**AUSTRALIAN RED CROSS BLOOD
SERVICE**

ACCESS REVIEW

Morris-Goding Accessibility Consulting

28th July 2008

03 SECTION THROUGH CAR PARK RAMP
1:400

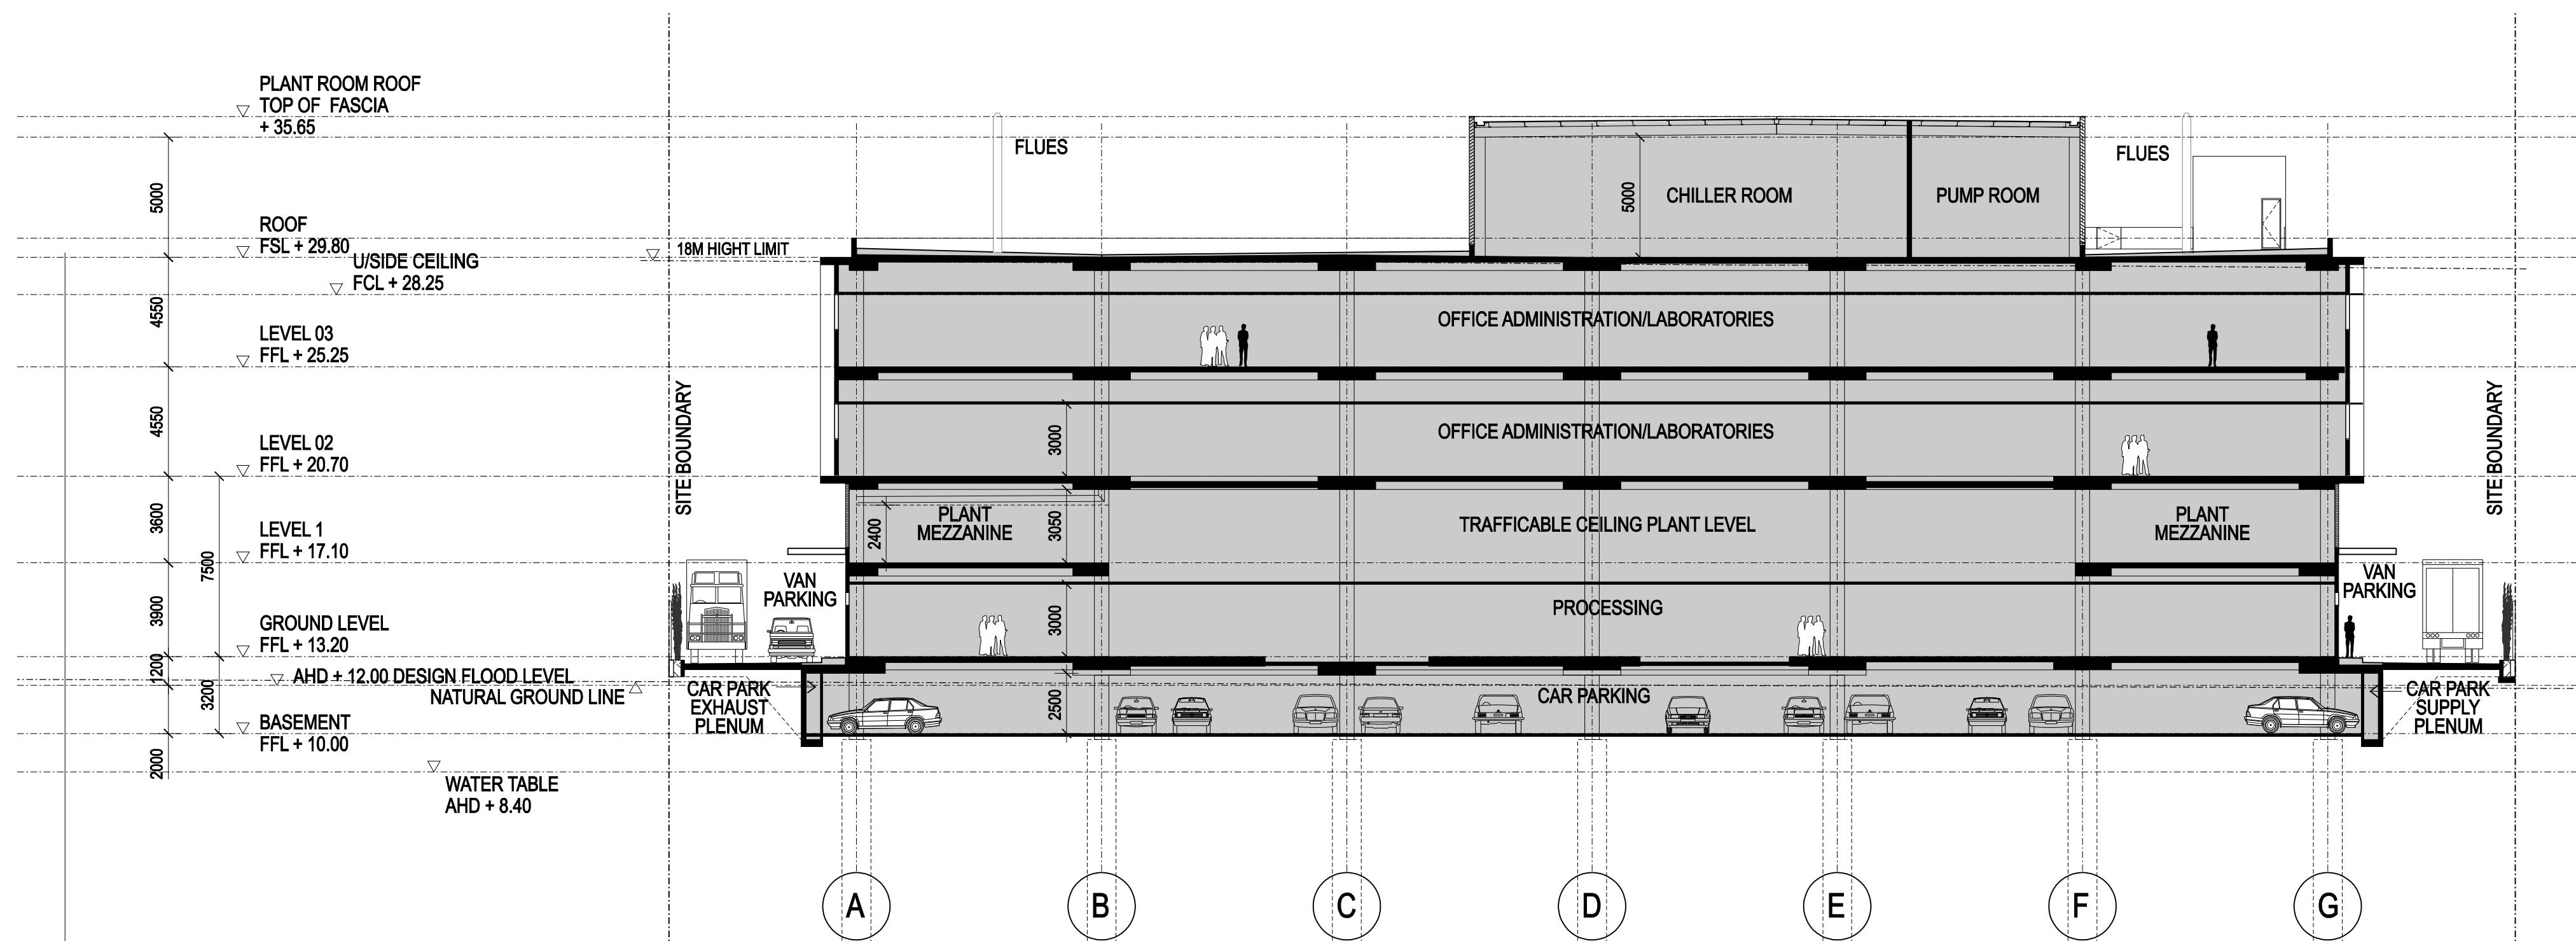
5.2. Accessible Car Parking

There is 1 basement level of car parking within the building, with approximately 88 staff car parking spaces and 9 visitor car parking spaces. The accessible car bays have been located adjacent to the lifts.

There are 2 staff accessible car bays and 1 accessible visitor car bay, which has been located adjacent lifts, which is compliant with the BCA and City of Sydney Council Access DCP 2004 requirements.

The staff accessible car bays have minimum dimensions of 3800mm x 5500mm. The visitor accessible car bays have minimum dimensions of 3800mm x 5500mm. These dimensions comply with City of Sydney Council Access DCP 2004 requirements.

Recommendation:

- (i) Ensure accessible car bays have minimum vertical height clearance of 2500mm above the bays and 2300mm leading to the bays.
